Recommendation Report for Planning Permission for Works or Extension to a Dwelling

REF NO: LU/217/25/HH

LOCATION: 8 Griffin Crescent
Littlehampton
BN17 7LJ

PROPOSAL: Single storey side/front extension.

ELEVATIONS,
SITE LOCATION AND
BLOCK PLAN

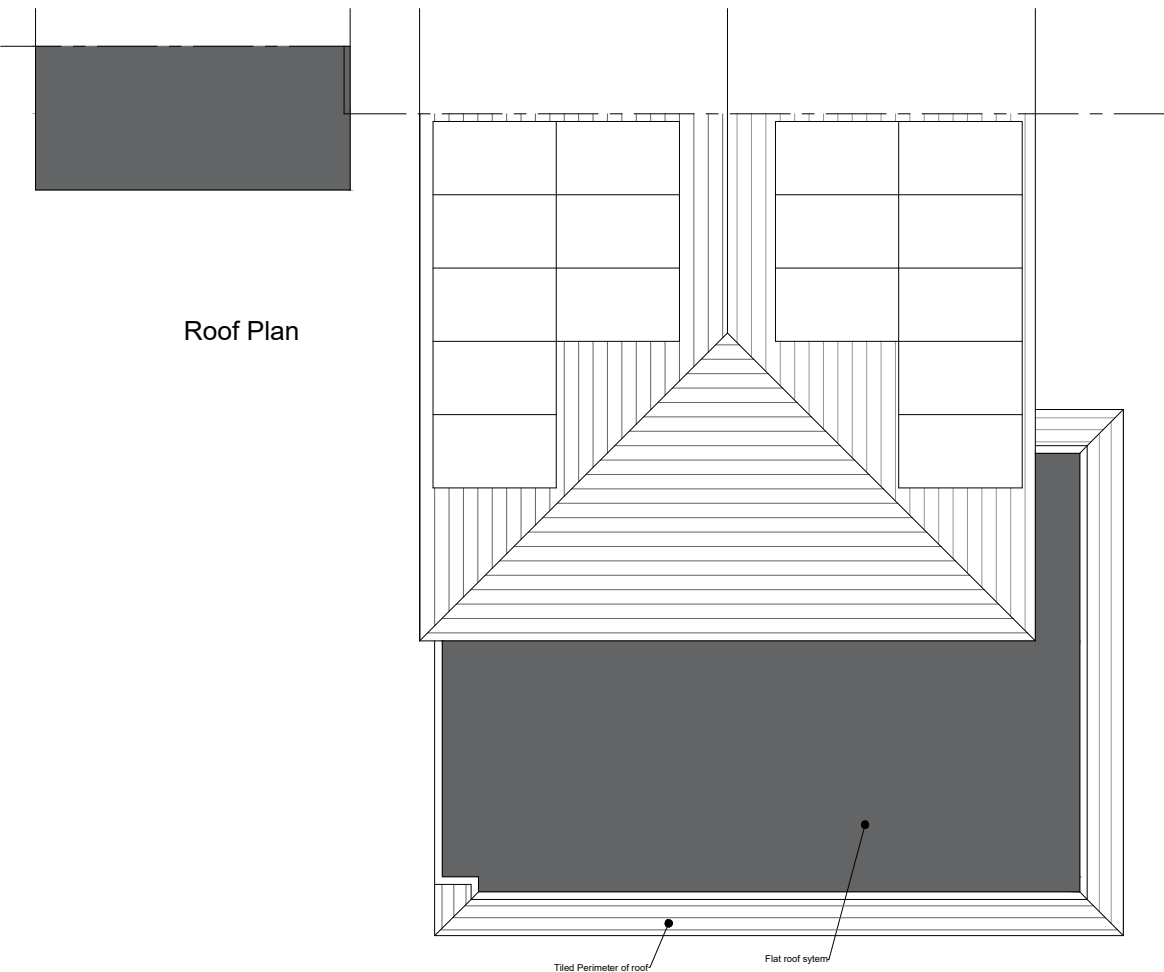
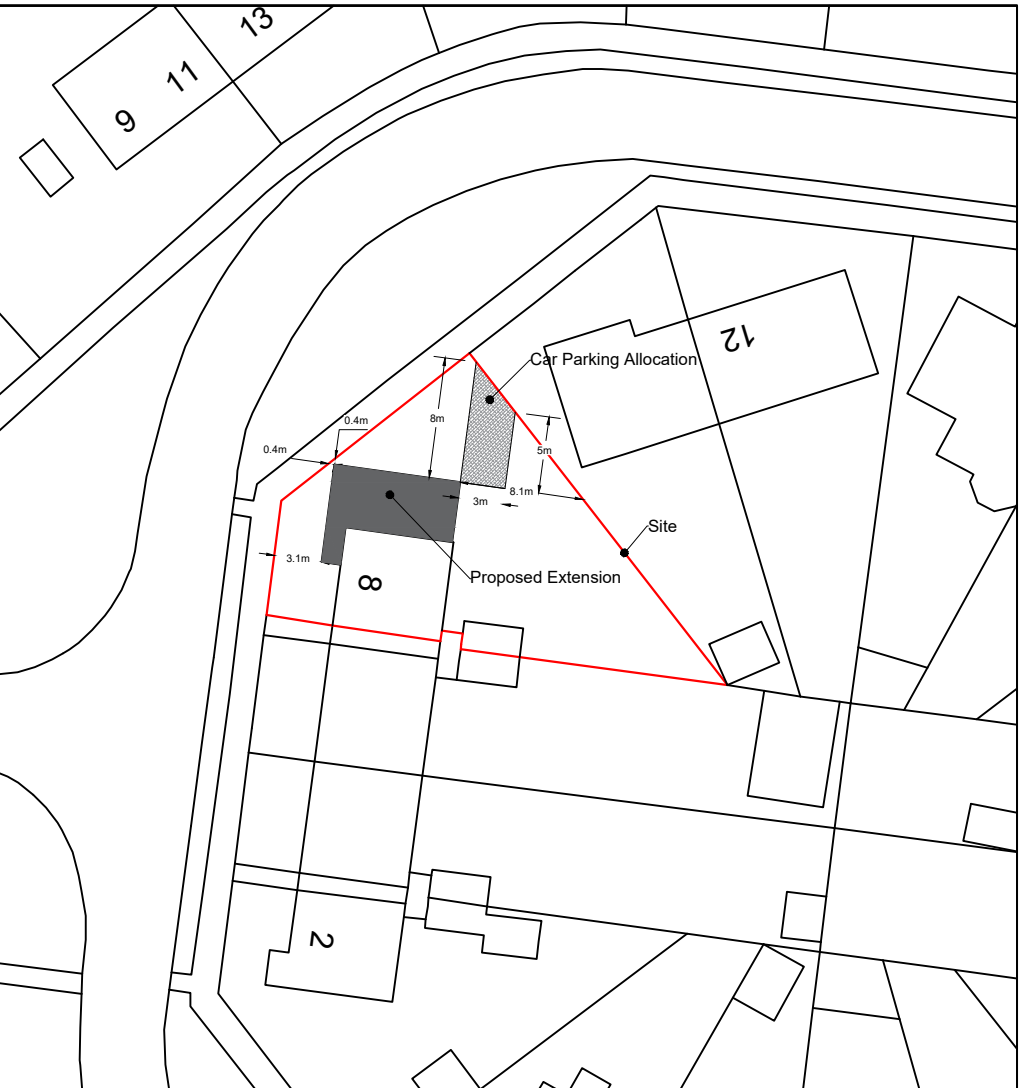
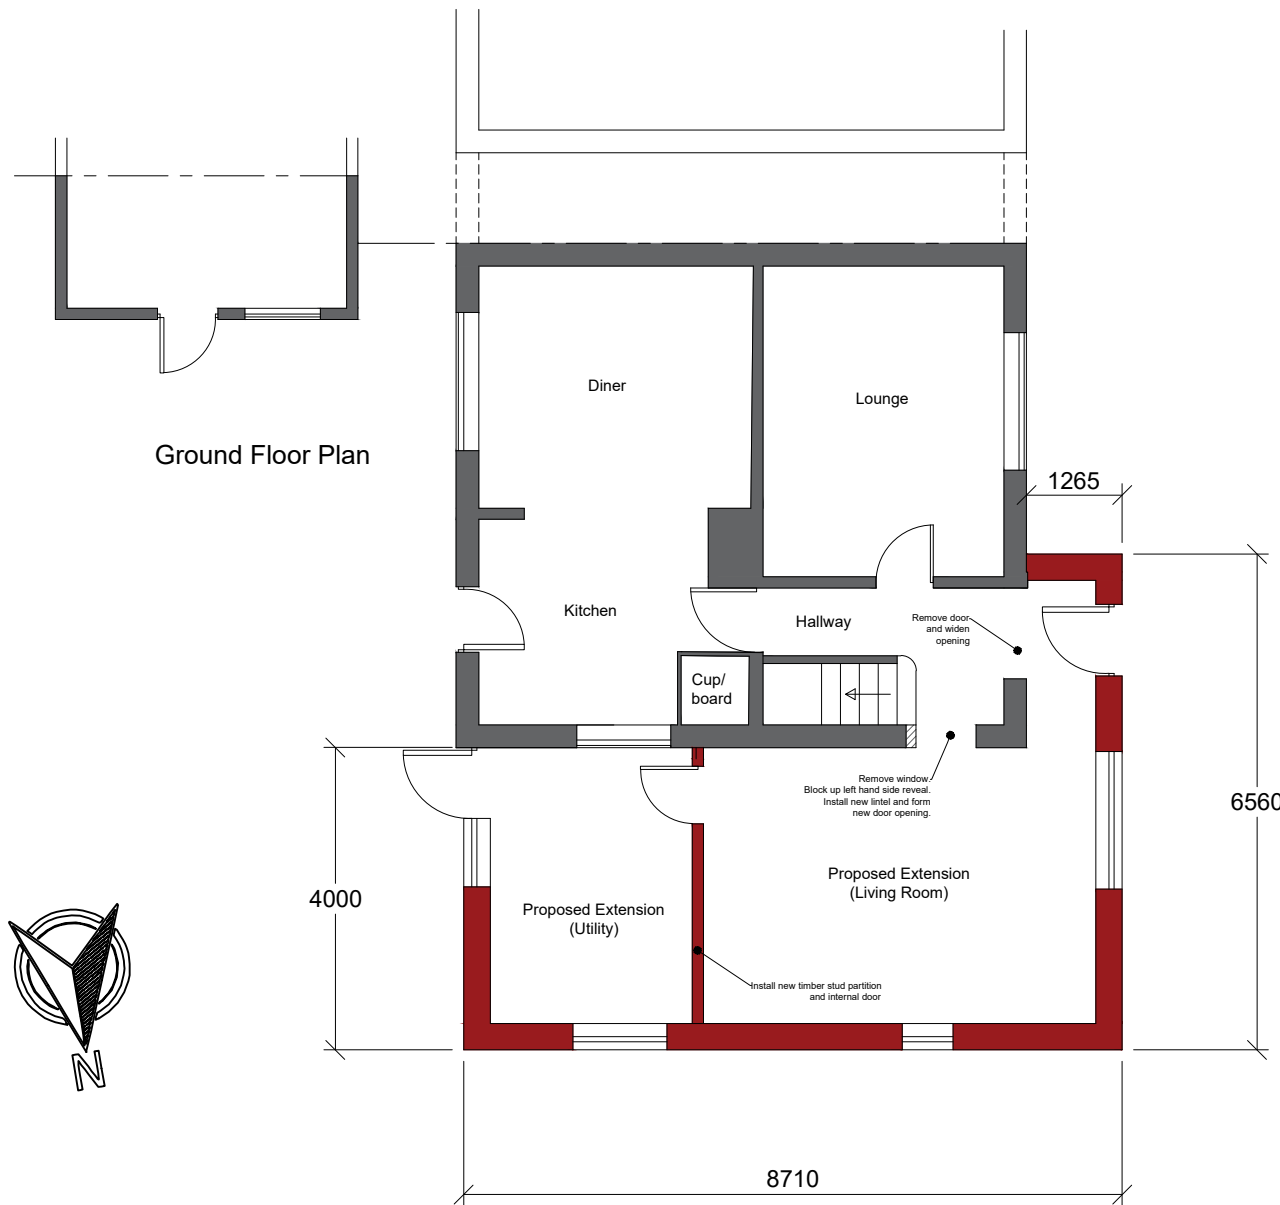
The site is an end of terrace dwelling seeking the addition of a single storey front/side extension. The extension would extend 1.3m forward from the principal elevation, with an overall depth of 8.7m, a maximum width of 6.6m, and an eaves height of 2.6m with a maximum height of 3.3m. The proposed extension would have a crown roof finished with tiles to match the existing roof. The walls would be brick and windows, and rear doors would be made from white UPVC to match the existing.

The proposed extension would be visible within the street scene, and it would extend closer to the highway than the existing. Notwithstanding this, it is noted that the street scene is varied, with various extensions present. Furthermore, the extension would reflect the character and appearance of the host dwelling in terms of its design. The extension would be finished in materials to match the host dwelling. Therefore, the proposed extension would not appear unduly prominent within the street scene, nor would it result in demonstrable harm to the character or appearance of the host dwelling, street scene, or wider area.

It is stated in the Arun Design Guide (ADG) that for front extensions, the proposal should take care not to disrupt the existing composition of the street in terms of rhythm or building line and ensure continuation of existing building design in terms of details and materials. Front extensions should generally be no deeper than 1.5m. The proposed works are in line with the Arun Design Guide and there are several examples of front extensions, and larger two storey extension in the street scene including at the east side neighbour, No. 10 Griffin Crescent. As such, the proposal is acceptable.

The extension would be set in approx. 0.4m from the boundary with the highway at its closest point. It is noted that between the boundary and the highway itself is a pavement and a grassed verge. The extension would be set in 8m from the east (side) neighbour. Given the siting of the proposed extension, it would not result in overbearing or overshadowing effects to neighbouring properties.

The north (side) elevation proposes two windows, in similar siting to the existing on this flank, which would not result in overlooking effects as the highway separates the host dwelling and the neighbour to the north. The east (rear) elevation would have a door and one window which would not provide views significantly different to those currently obtained from the rear fenestration. The extension would not result in overlooking effects.

The proposal requires changes to the current parking layout. The proposed extension would result in the loss of two parking spaces to the side of the host dwelling. Whilst it is noted that the submitted block plan indicates parking retained for one vehicle, this could not be accessed in the absence of a new dropped kerb arrangement.

It is noted that the proposed extension would result in the loss of the existing parking arrangements as the hardstanding area for parking would become inaccessible. Consequently, on-site parking would not

be available. Nonetheless, unrestricted on-street parking is available in the vicinity and as such, the proposal would not result in harm to highway safety and the proposal is acceptable in this instance.

Site Location Plan, Block Plan, Floor Plans and Elevations SD1117-01A
